Subject	2-32 SMITH STREET, SUMMER HILL, PROJECT APPLICATION
File Ref	FM APRIL 2013
Prepared by	Con Colot - Senior Strategic Planner & Projects
Reasons	Provide the Department of Planning & Infrastructure with comments on the Project Application for Stage 1 at the Flour Mills site, 2-32 Smith Street Summer Hill.
Objective	For Council to determine its response to the project plan application.

1.0 Purpose of Report

SCHEDULE OF LOTS & NOTATIONS

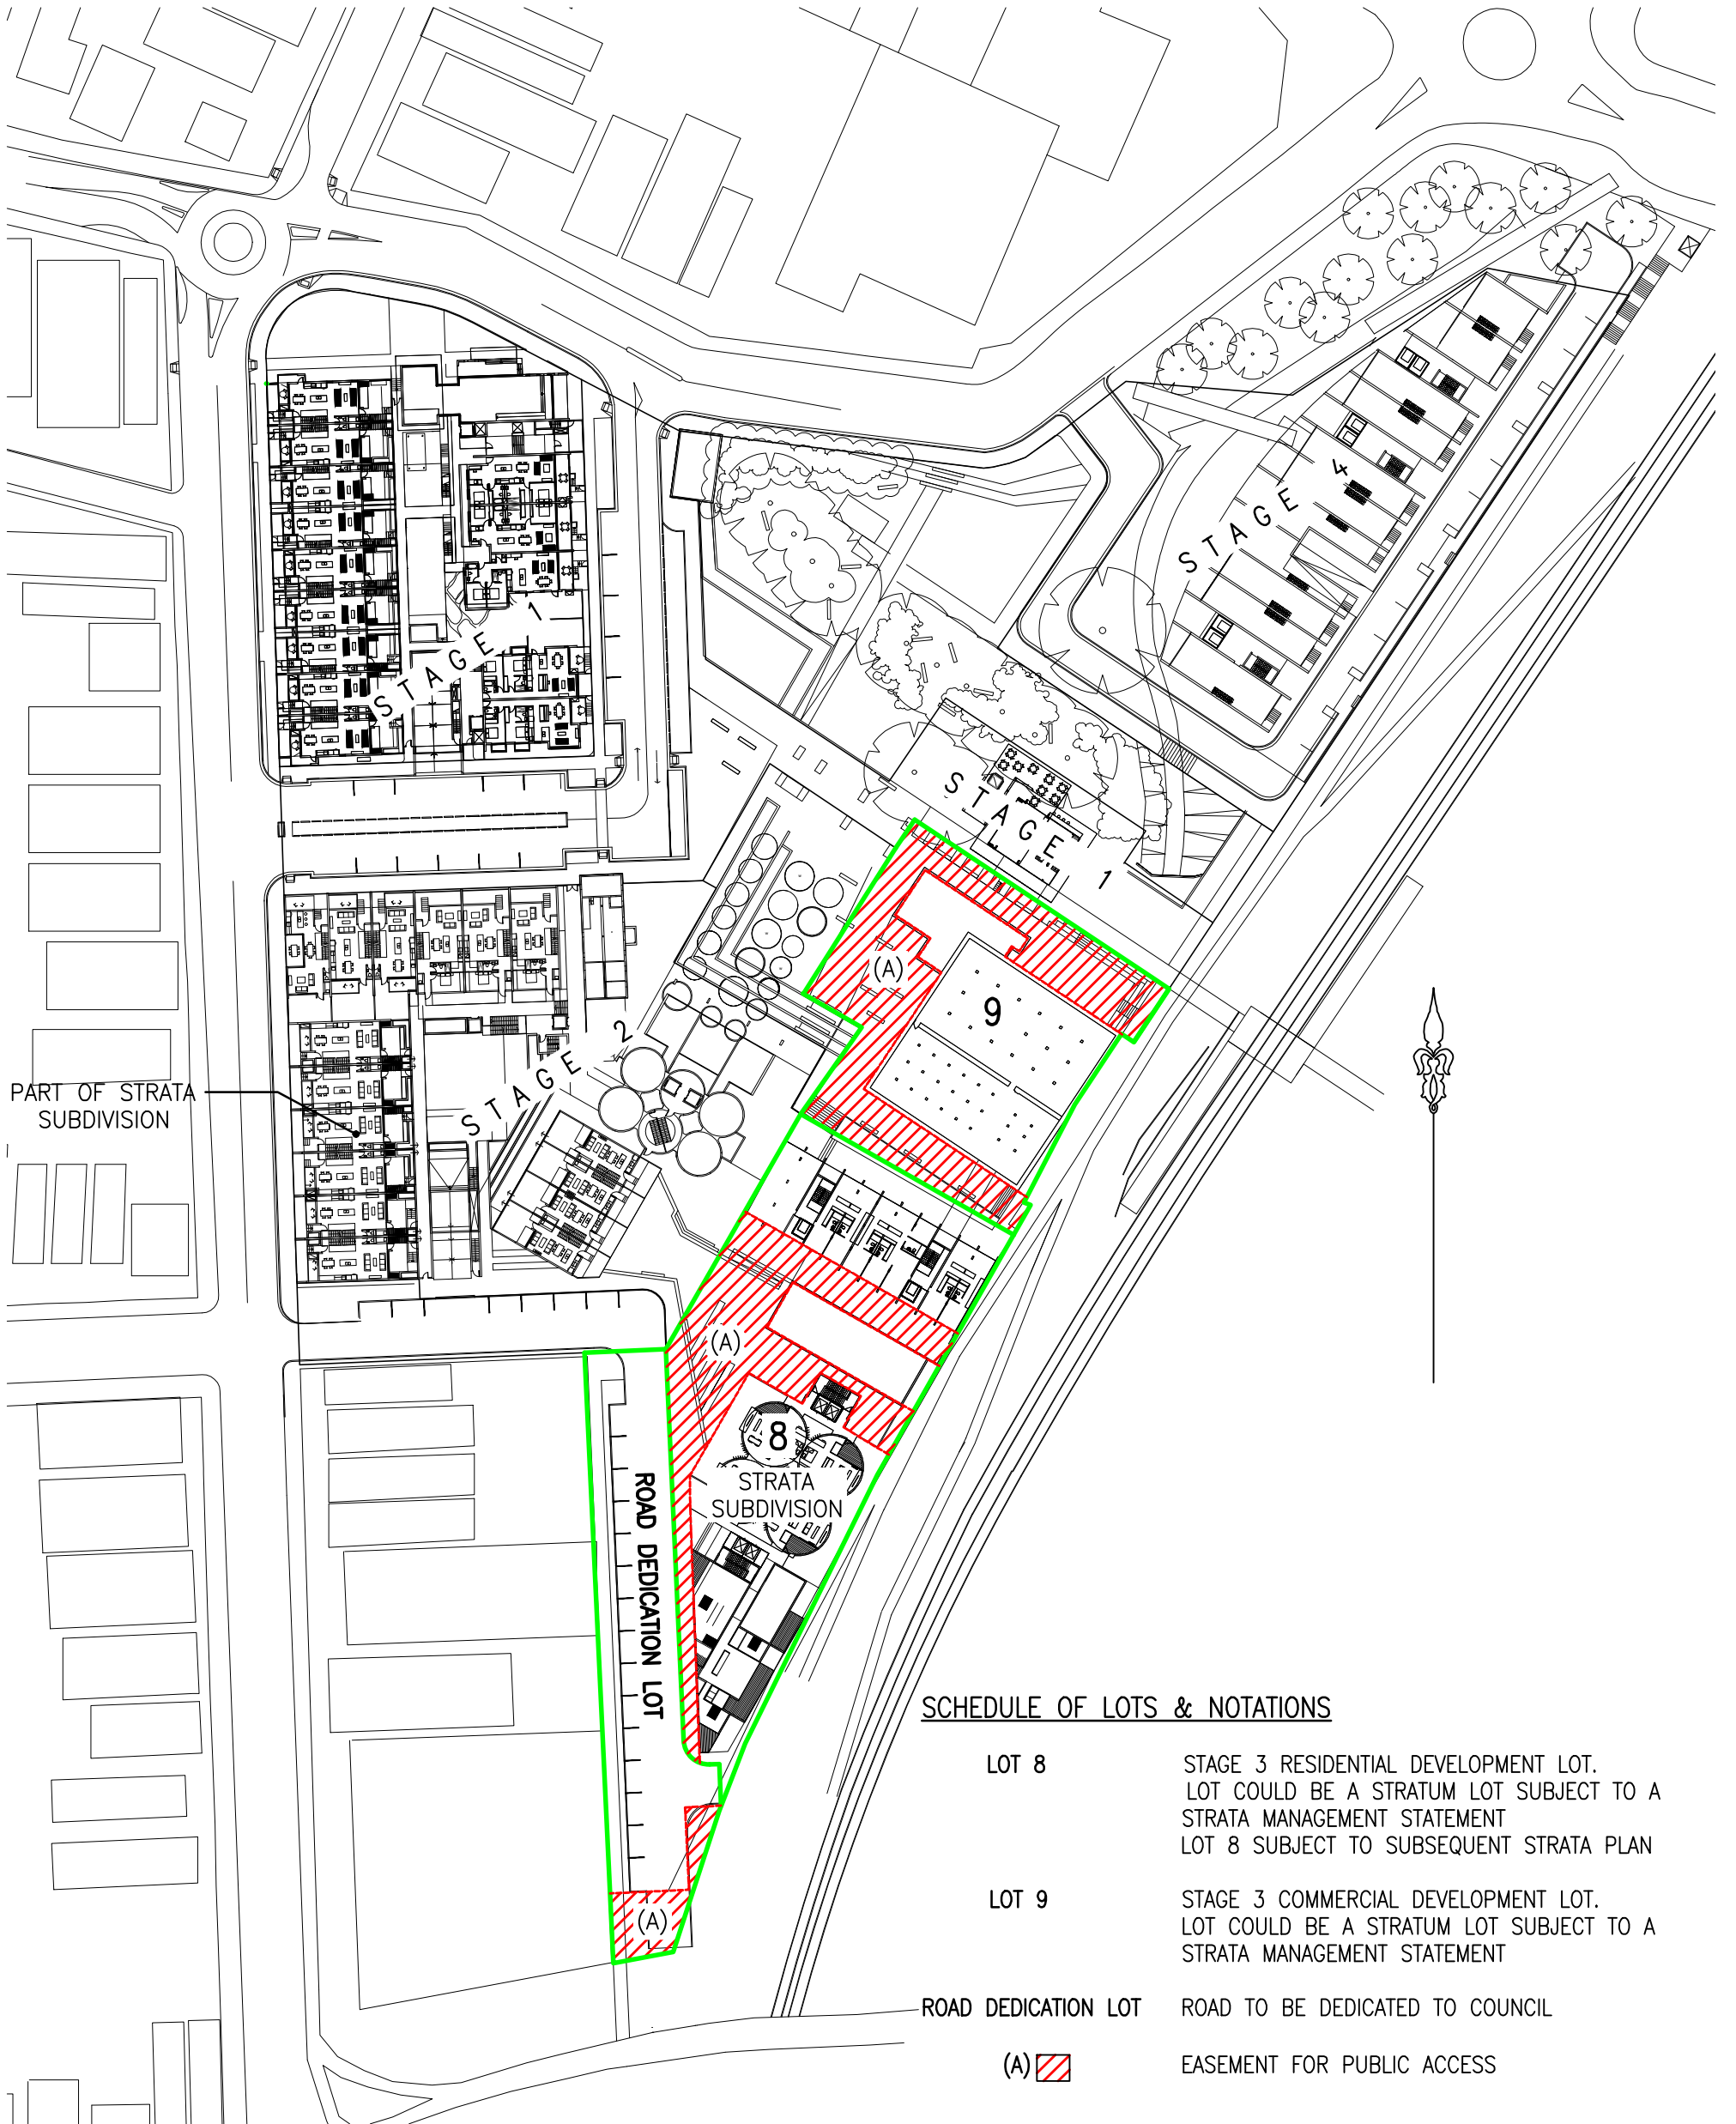
The development is proposed to be staged in 6 parts, as shown on the 'Indicative Subdivision Plan' (DA -012), and as shown in **Diagram 2** of this report.

As previously brought to the attention of the Department, once land subdivision occurs, each allotment will potentially be able to be sold to individual owners and separately developed. This creates uncertainty about how each development stage will address the complexities and share the burden of complying with the numerous Concept Plan conditions, and for example provide the various infrastructure works located on other parts of the site or external to the site. Another issue is whether different land owners will be willing to comply with the Concept Plan approval conditions, or instead seek amendment of the conditions.

In order to provide certainty to the Concept Plan approval conditions 23, 24, 25 and 26 (see extract under **Diagram 2**) which require publicly accessible open space and a public access way to the Light Rail station, a condition should be placed on any Project Application approval reflecting the Concept Plan conditions 23, 24, 25 and 26 and requiring that the relevant 'restriction as to user' be placed on all the relevant land titles.
